From: dane@tnesinc.com
Sent: Monday, June 18, 2018 2:25 PM
To: jmaynard@nescolorado.com
Cc: Marc Whorton; 'Luanne Ducett'
Subject: Timberridge Estates - Revised Drainage Report
Attachments: 173300 FDR.pdf

**PRELIMINARY/FINAL DRAINAGE REPORT
FOR
TIMBERRIDGE ESTATES, PRELIMINARY PLAN
PART OF THE RETREAT AT TIMBERRIDGE
(NORTH OF ARROYA LANE)**

Job No. 1733.00

SP-18-002

THE RETREAT AT TIMBERIDGE
PRELIMINARY DRAINAGE REPORT
(SOUTH OF ARROYA LANE)
DEVELOPED DRAINAGE MAP

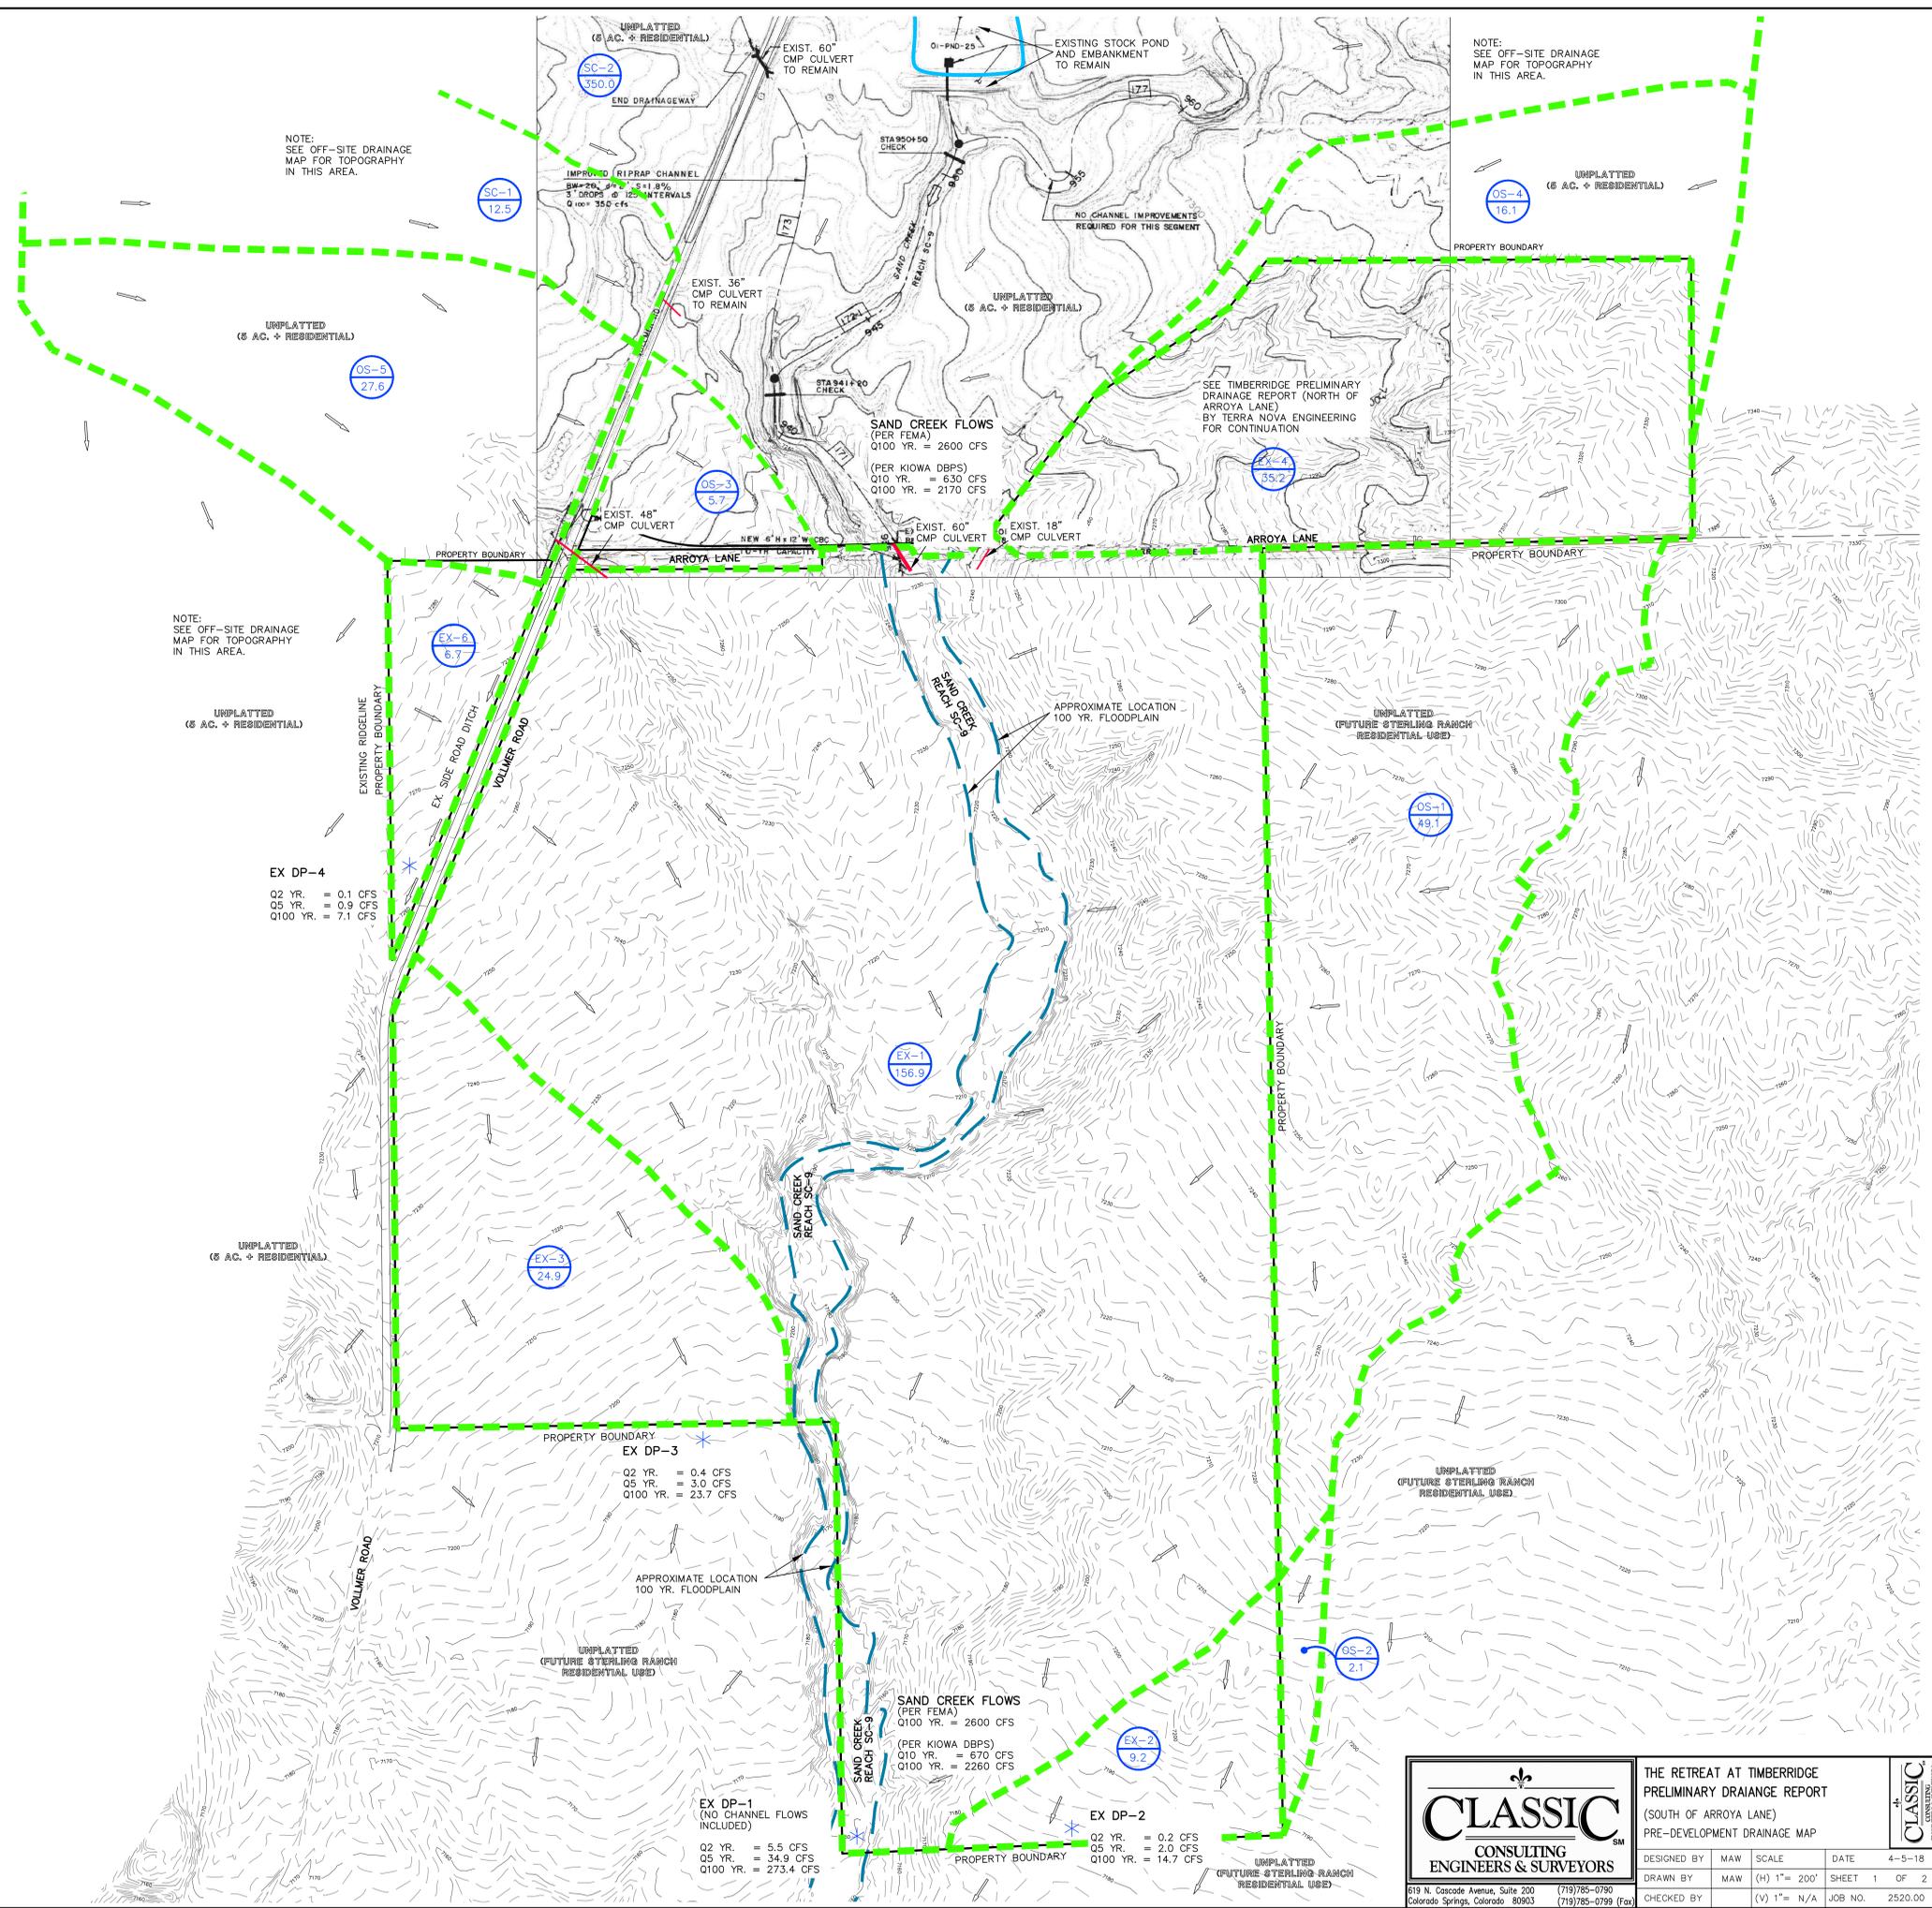
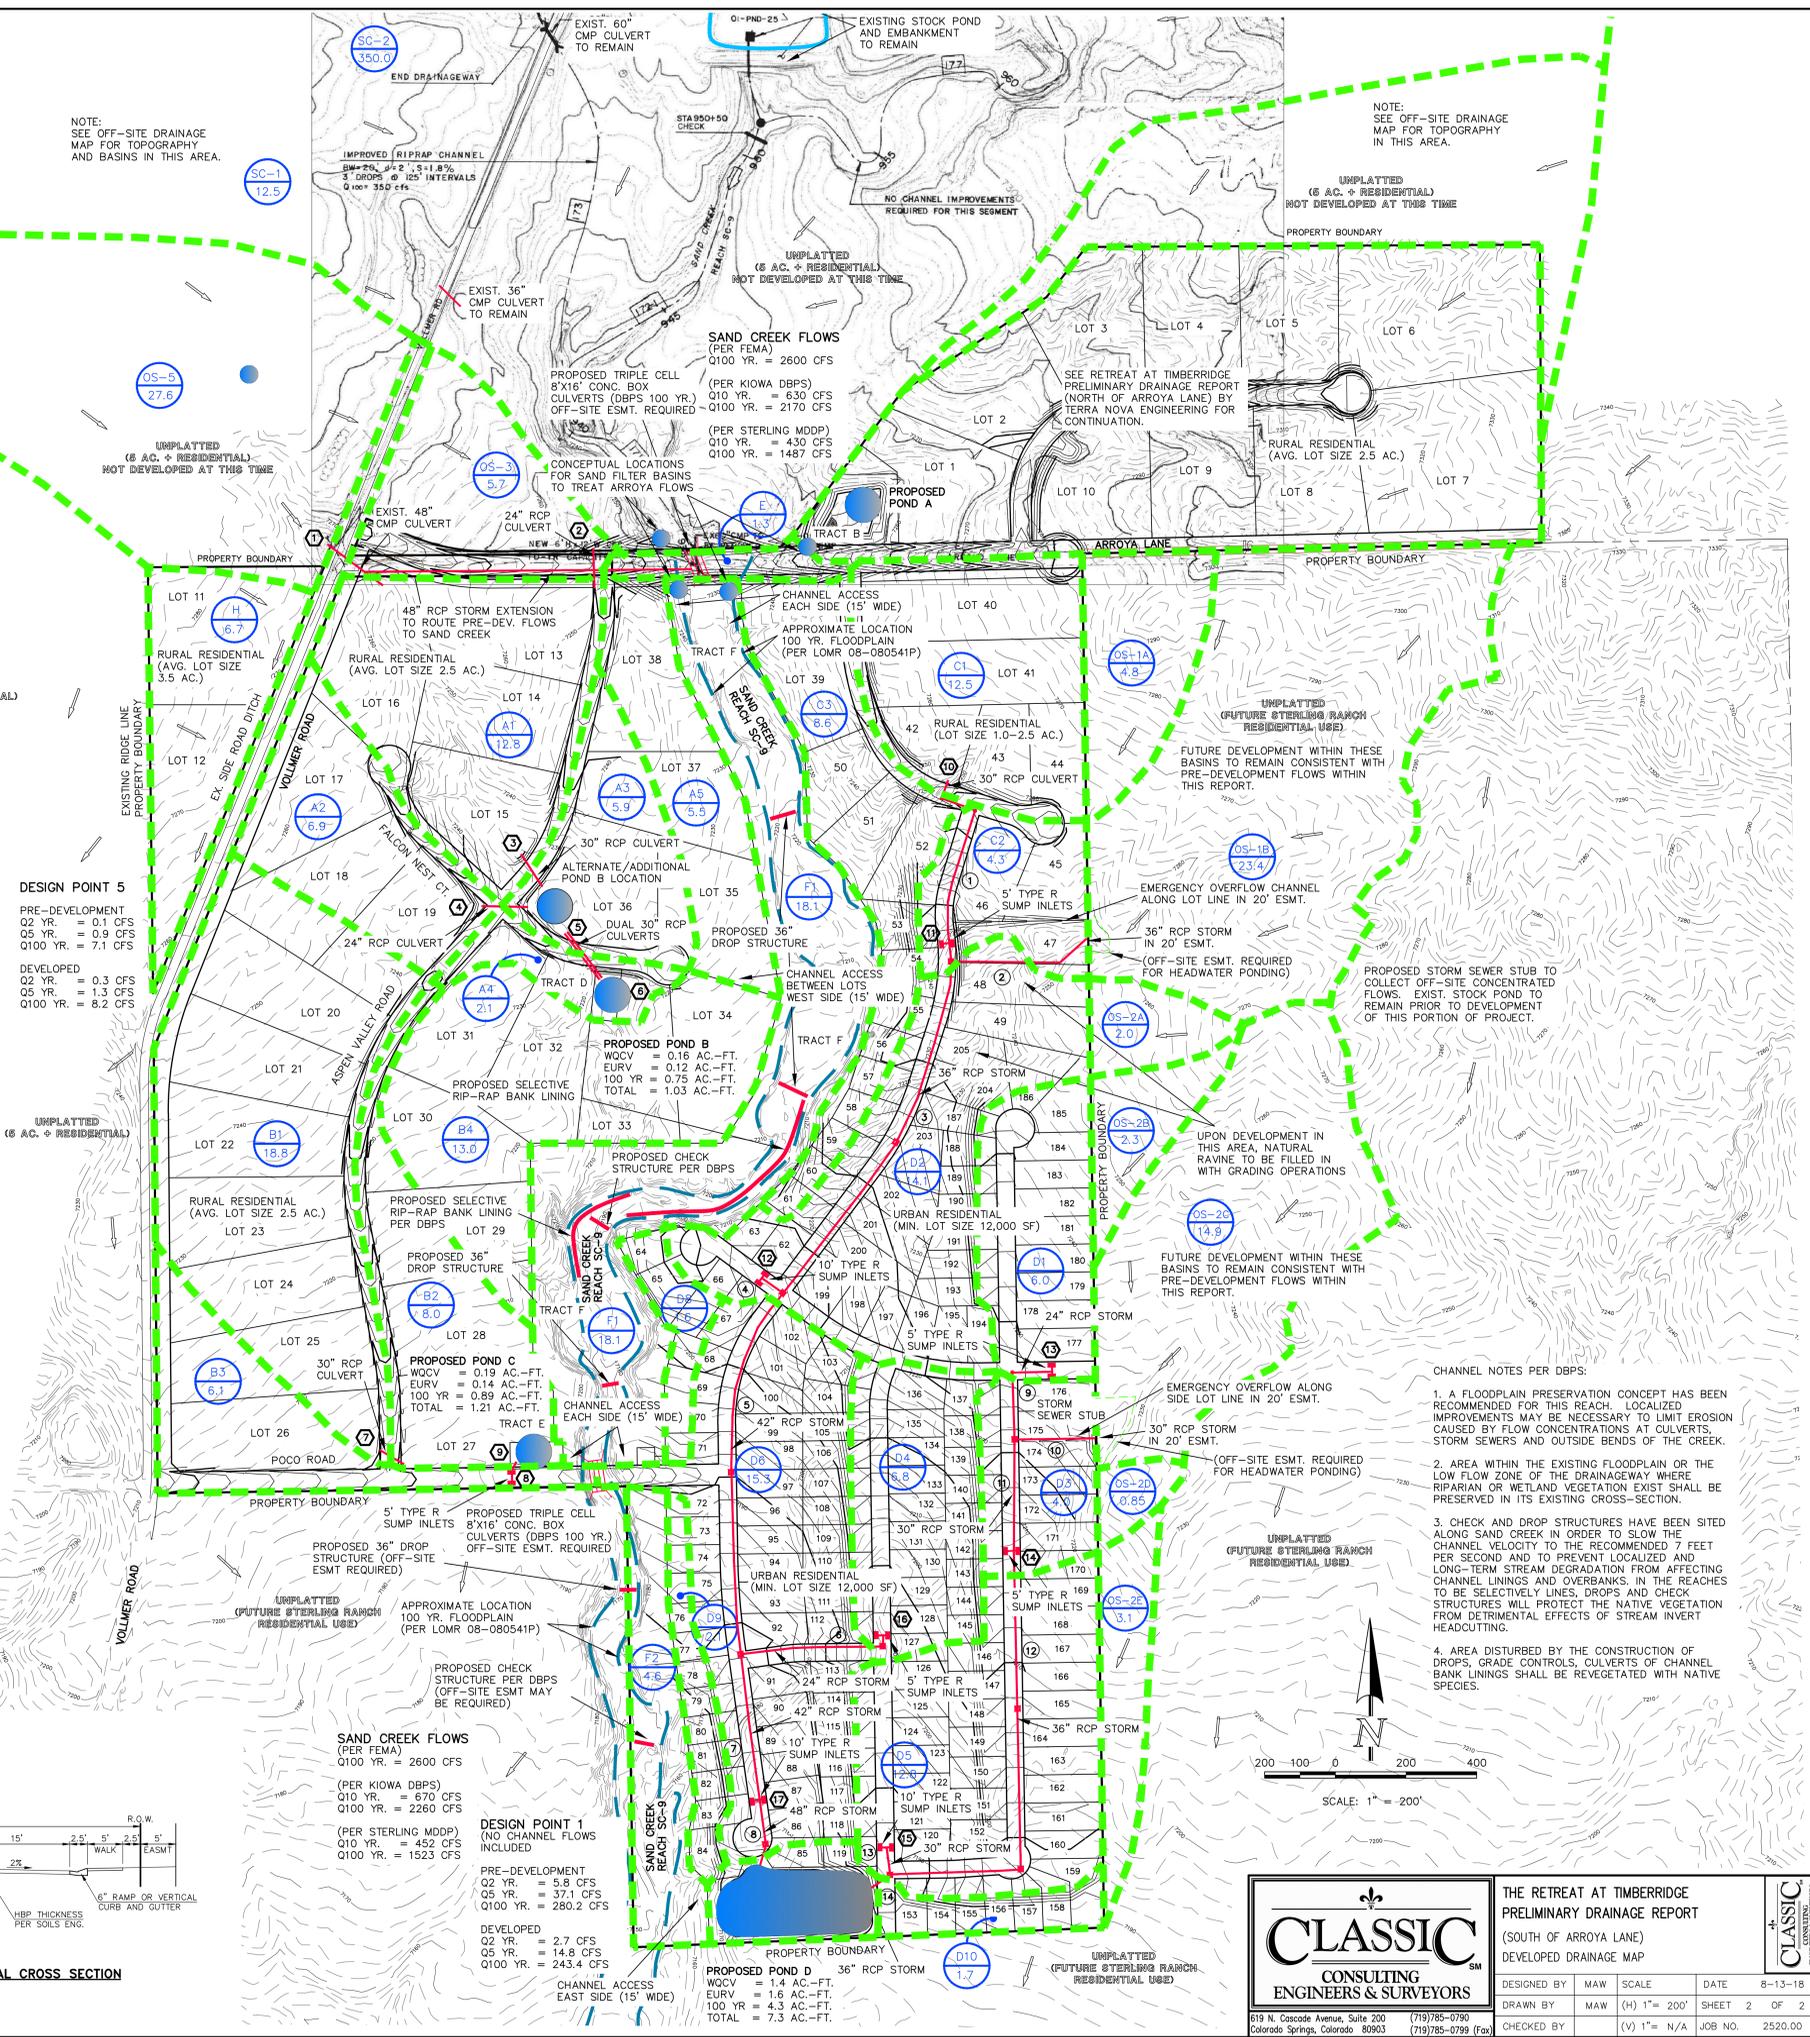
- Proposed Drainage Plan – Q: What is this line?, A: It is the boundary of a surface feature in CAD, which shouldn't have been shown.
- Proposed Drainage Plan – Q: From the contours it appears that this flow crosses Arroya Lane. Is there a culvert?..., A: Flow does cross Arroya Lane after ponding at least 2 feet. Looks like some flow may also go west along Arroya Lane after ponding (couldn't be sure since everything was dry). There is no culvert there, just a cattle guard. We aren't rerouting this flow as it's outside the development

- Proposed Drainage Plan – C: Stabilized spillway outfall needs to be entirely within the property., R: It is (shown ending at the property line).
